Addendum No. 1

RE: Contract # C204621

BRIDGE 103 ON NC-268 OVER MITCHELL RIVER

The following revisions have been made to the Roadway plans.

PROJECT REFERENCE NO. BR-0048	SHEET NO. 5
ROADWAY DESIGN ENGINEER SEAL 025878 SHERI E. COLLOUP SHERI E. COLLOUP 412.927.4276	HYDRAULICS ENGINEER SEAL 020870 MARC T. SHOWN MARC T. SHOWN 412.927.4276
DOCUMENT NOT CONSIDERED FINAL UNLESS ALL SIGNATURES COMPLETED

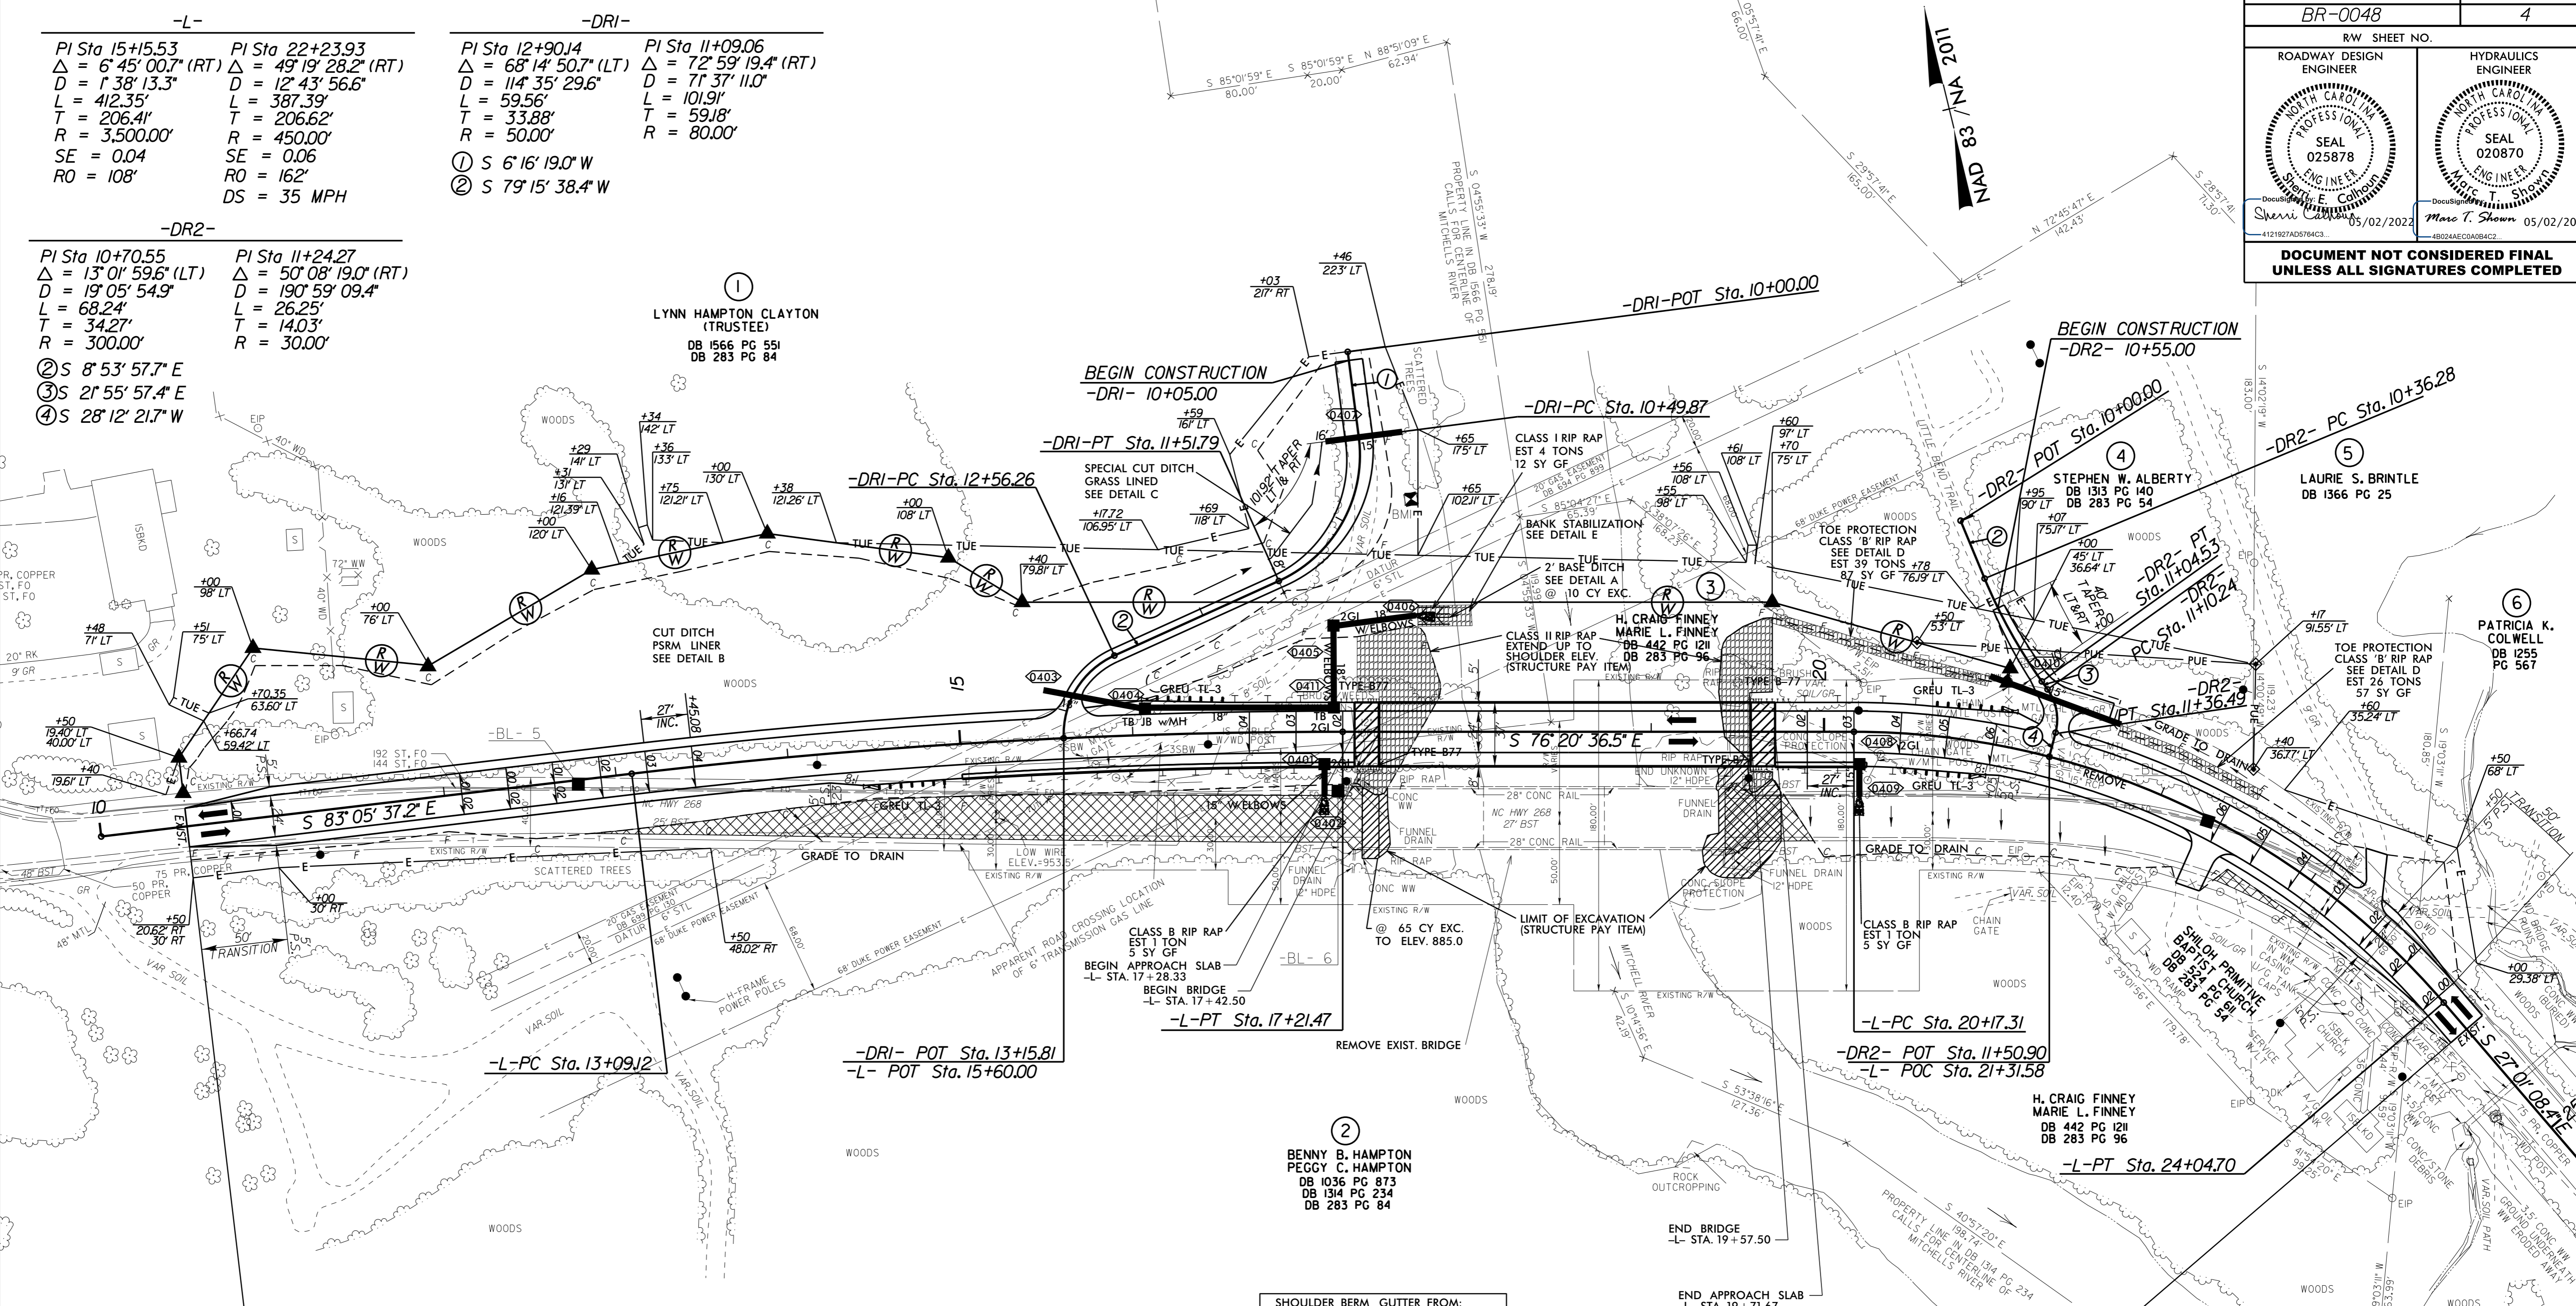
Sheet No.	Revision
1A	Revised to add 3 additional standards
3D-1	Updated quantities and elevations to reflect new design
4	Revised drainage to avoid gas line conflict. Revised Drainage Structures 404 and 405. Added Drainage Structure 411
EC-4	Revised EC measures to reflect change in drainage
EC-5	Revised EC measures to reflect change in drainage
